Re: Development Application D/2017/349 (SSD 8105)

My objections to this DA, as presented, are based on items from the Secretaries Environmental Assessment Requirements (SEAR) which are discussed below.

Private View Analysis | 116 Bathurst Street

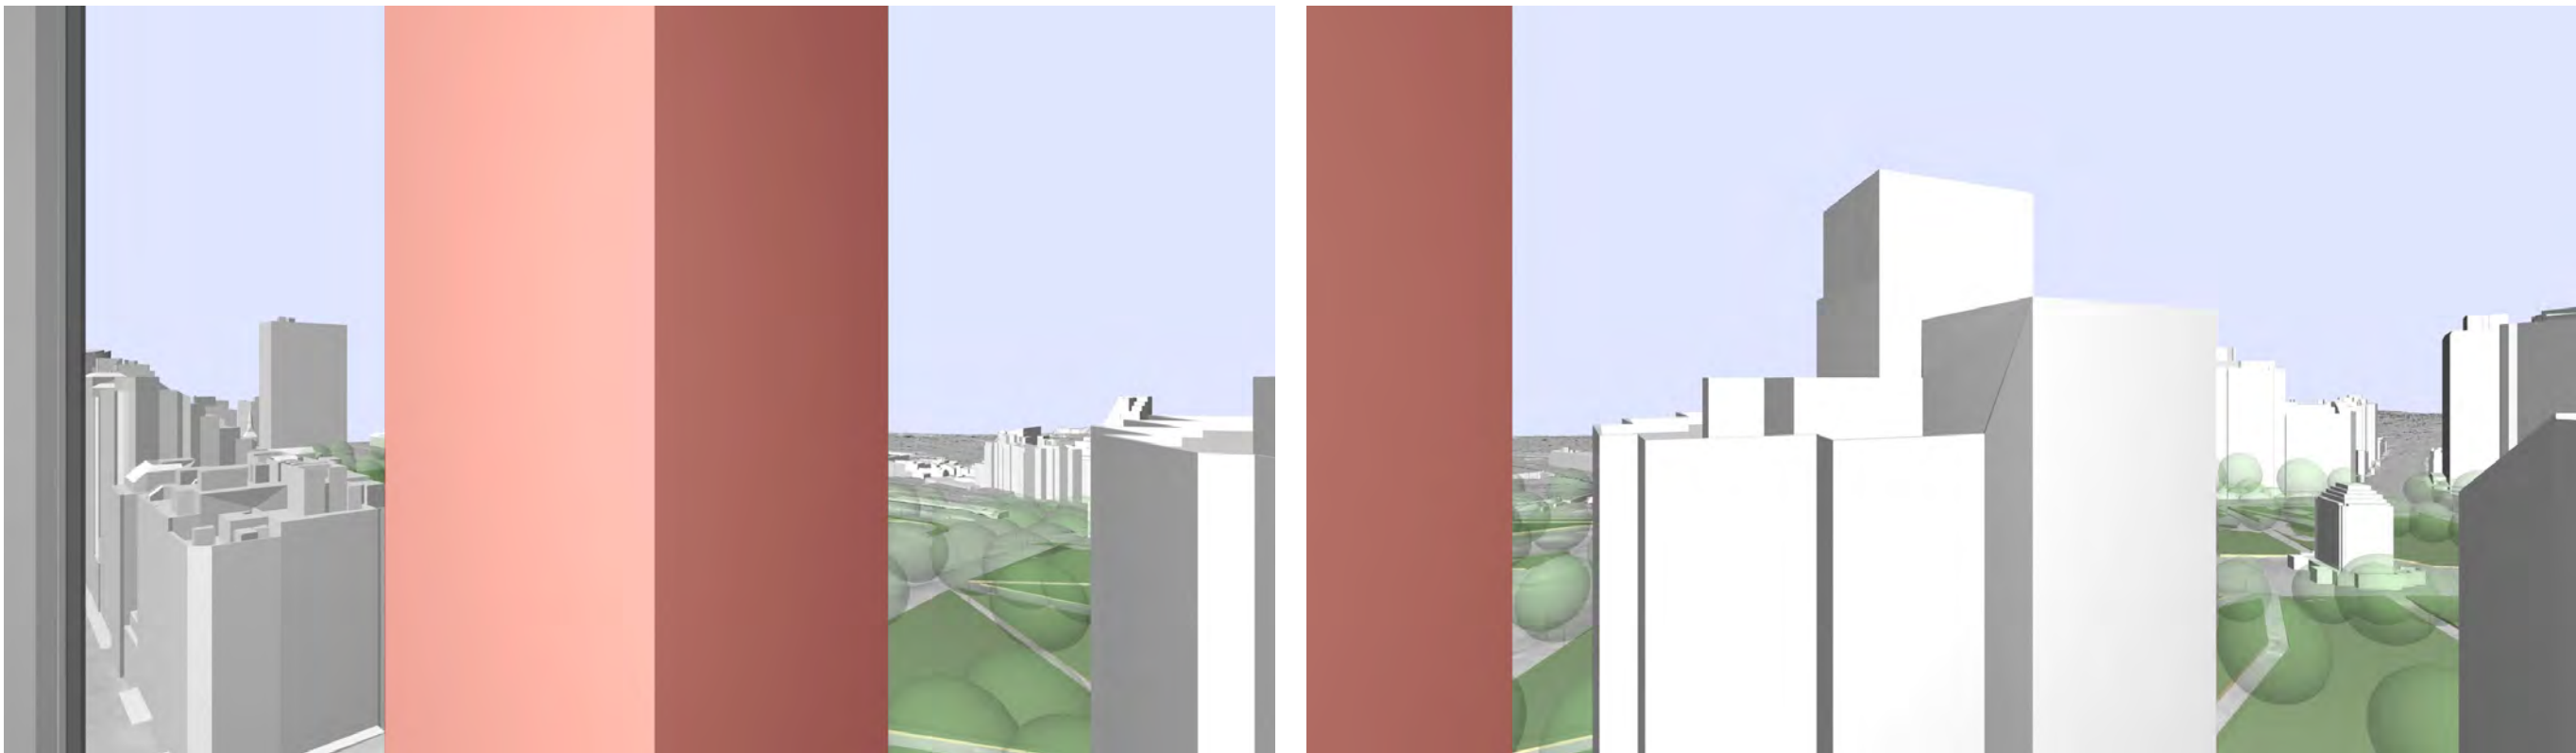
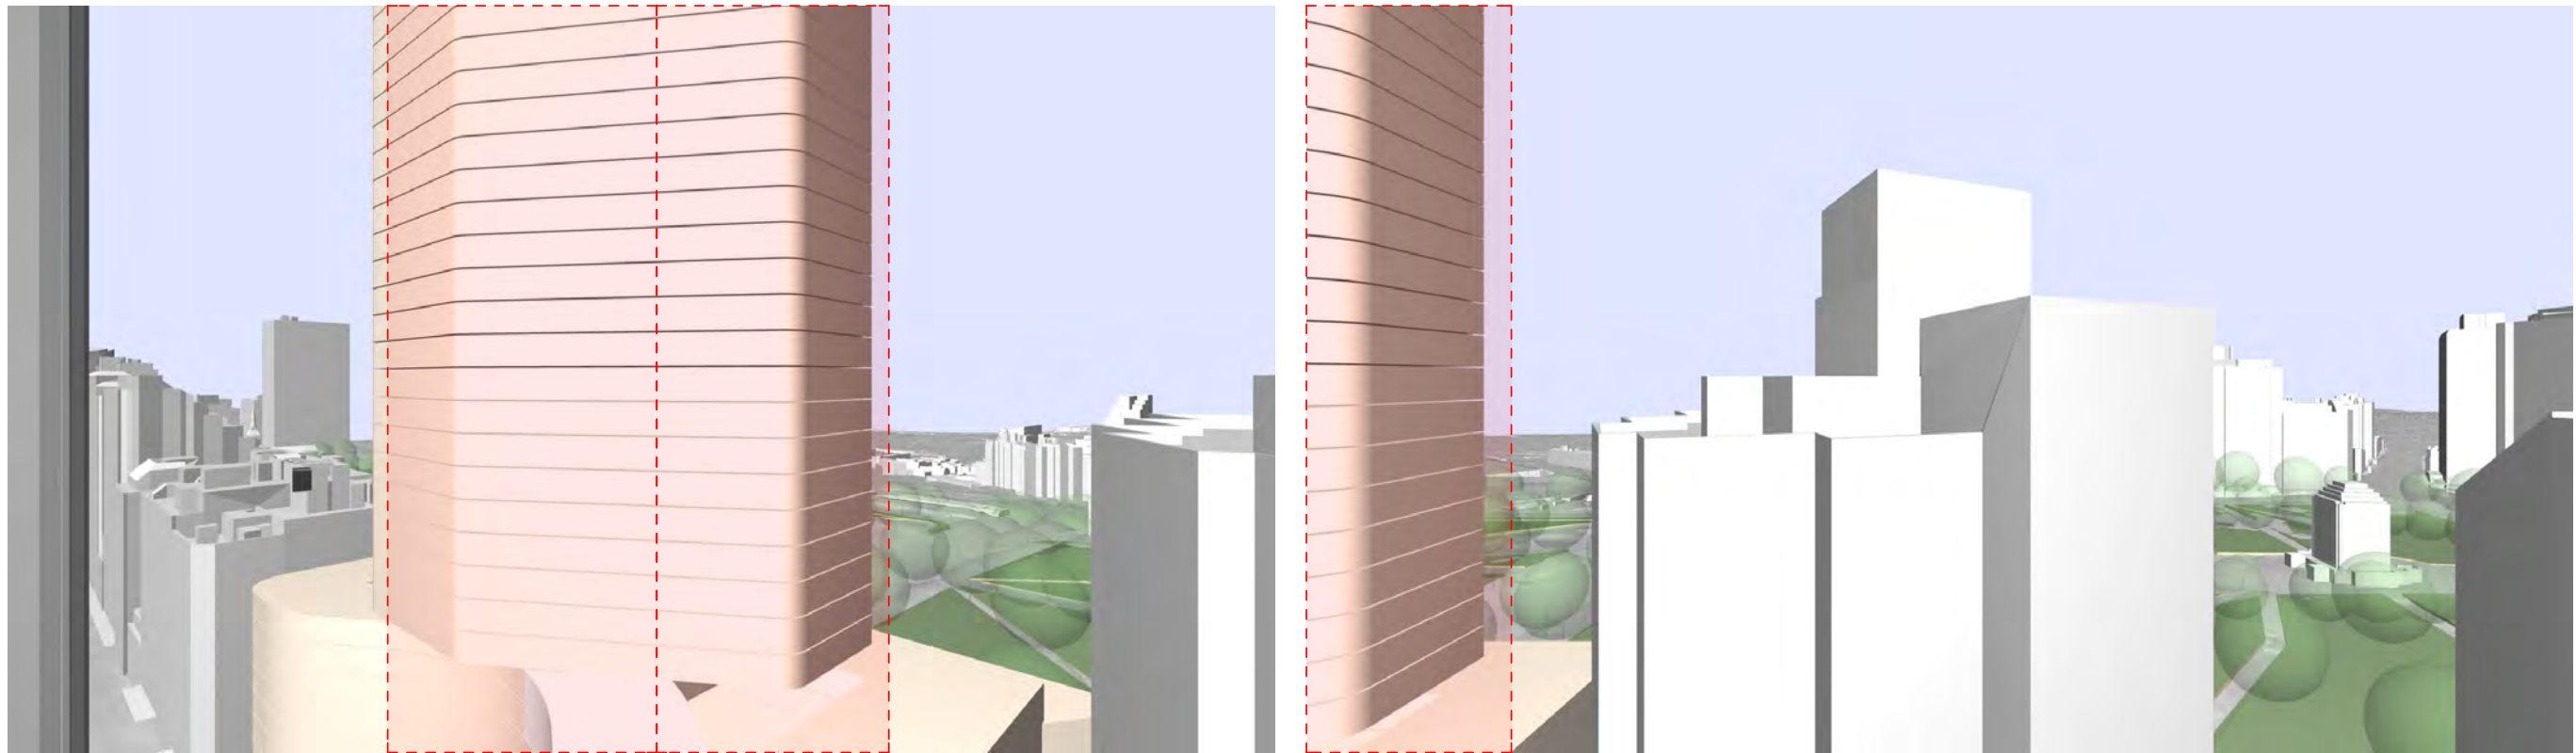
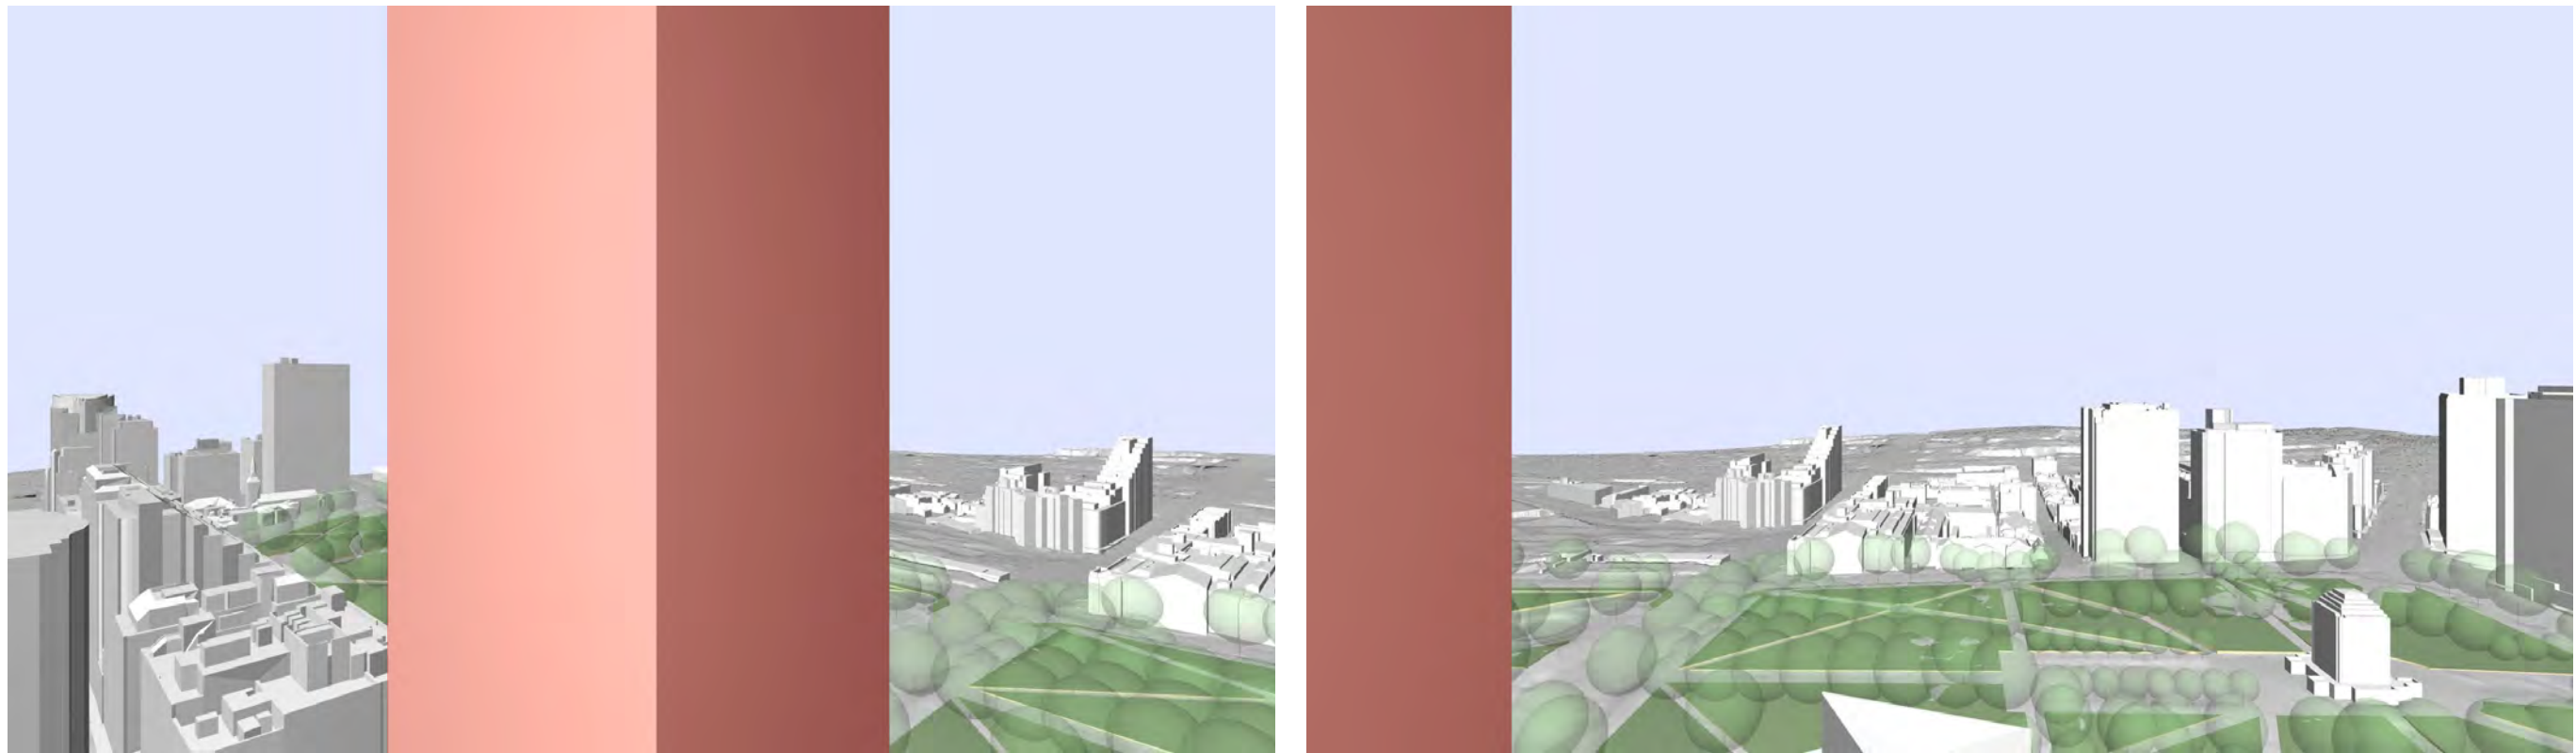
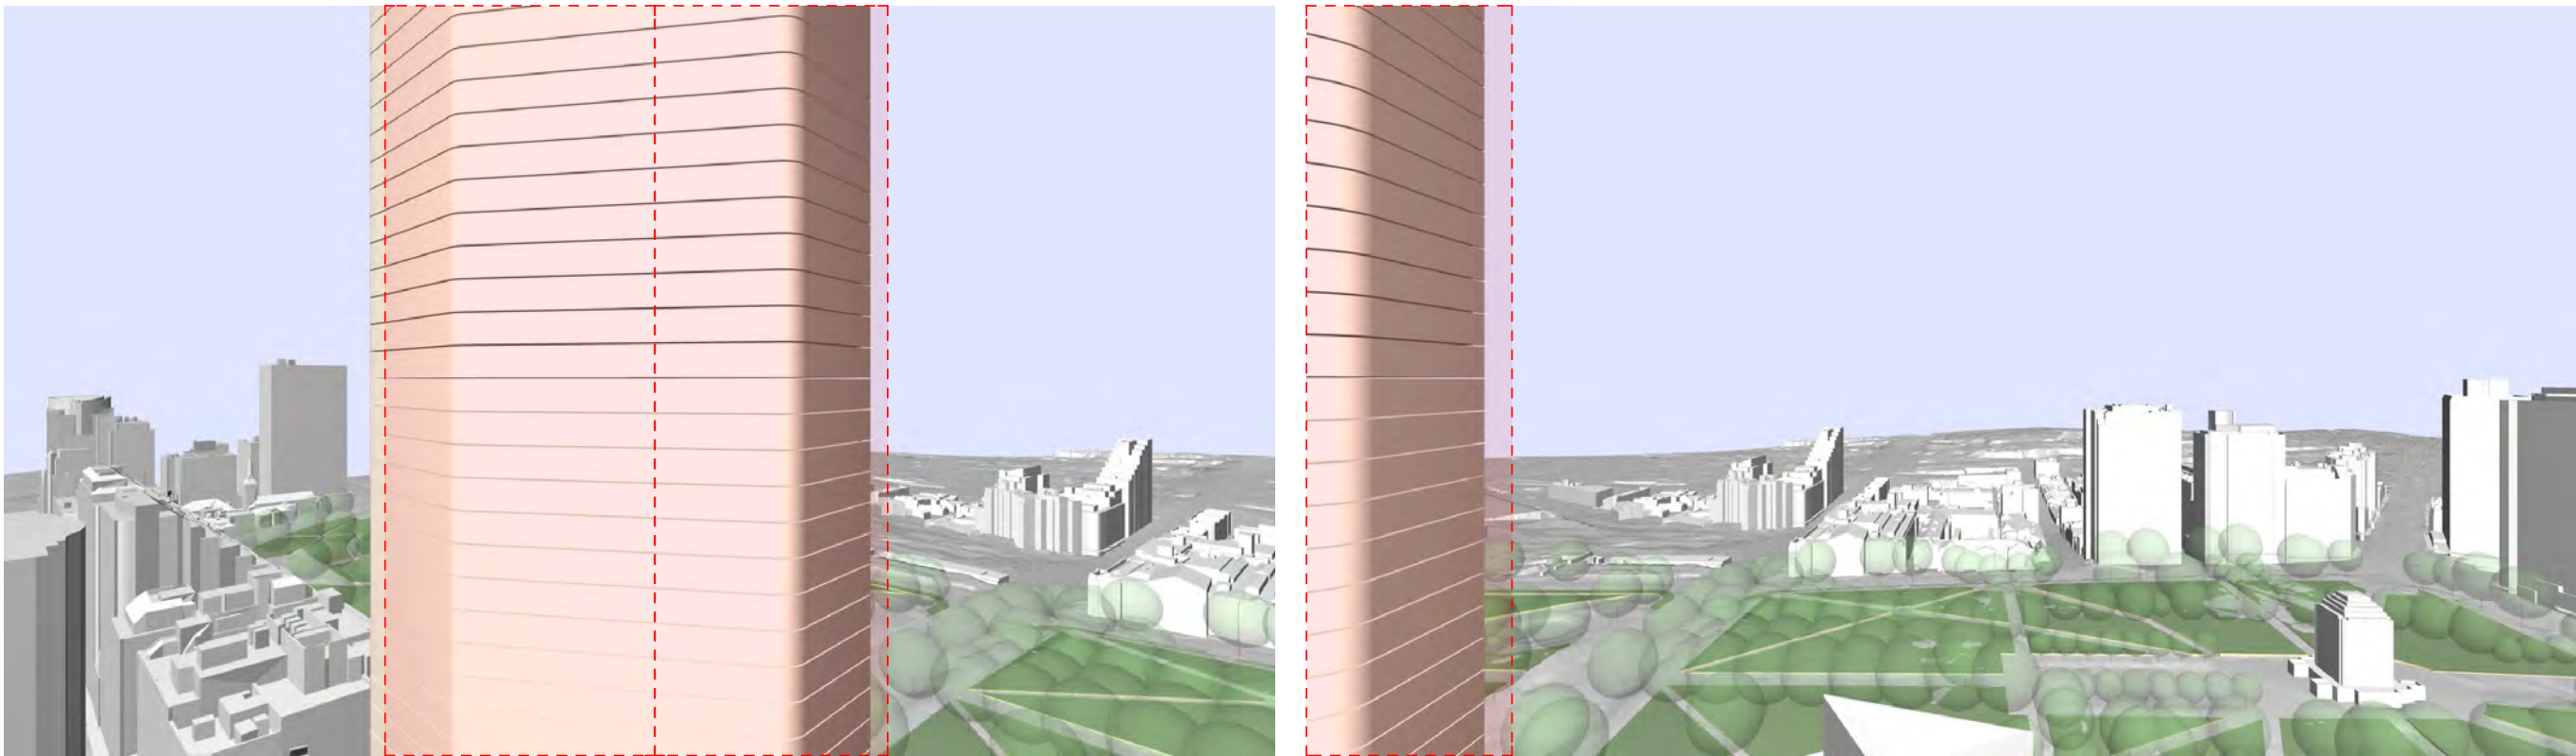
Design excellence is also lacking in some aspects of this development. Amenity will be lost for many surrounding residents. The outlook from my apartment is significantly reduced. I would think the loss would be approximately 70% by area. The DA shows the view extending as far as St Mary's Cathedral (Appendix D Design Report Part 5 Pgs. 66-67) but, as evidenced in Attachment 2, it goes down Sydney Harbour to the Heads. I expected to lose some amenity but not this much.

Dexus in their Property DA, (page 73 of the Environmental Impact Statement) quote previous judgments by "council officers assessments" relating to the loss of view. From the Greenland's Development at 115 Bathurst Street Sydney, it was stated that it was "*unreasonable that the entirety of such a view could be maintained*". From Mirvac's redevelopment at 200 George Street Sydney, it was concluded that the extent of view loss experience by the alternative building envelop was acceptable because it "*only result[ed] in the loss of partial views*". Following on from the direction of these the judgments, a **70 percent loss of view**, which I would experience, would be deemed unacceptable (Attachment 2). This is especially pertinent as moving the proposed tower to the centre of the development would restore most of the views with very little inconvenience to the developer.

- The tower be retained in its original position, albeit at the proposed angle and height.
- The bulk of the podium be lessened to approximately 75 percent increase from the original footprint.
- The pedestrian link to Museum Railway Station be retained.
- The number of traffic crossings on the footpath in Castlereagh Street be decreased.
- The footpath widths be retained.
- All the factors rated in the "Options Considered" are either the same or could be designed out for a central tower compared to a northern tower.
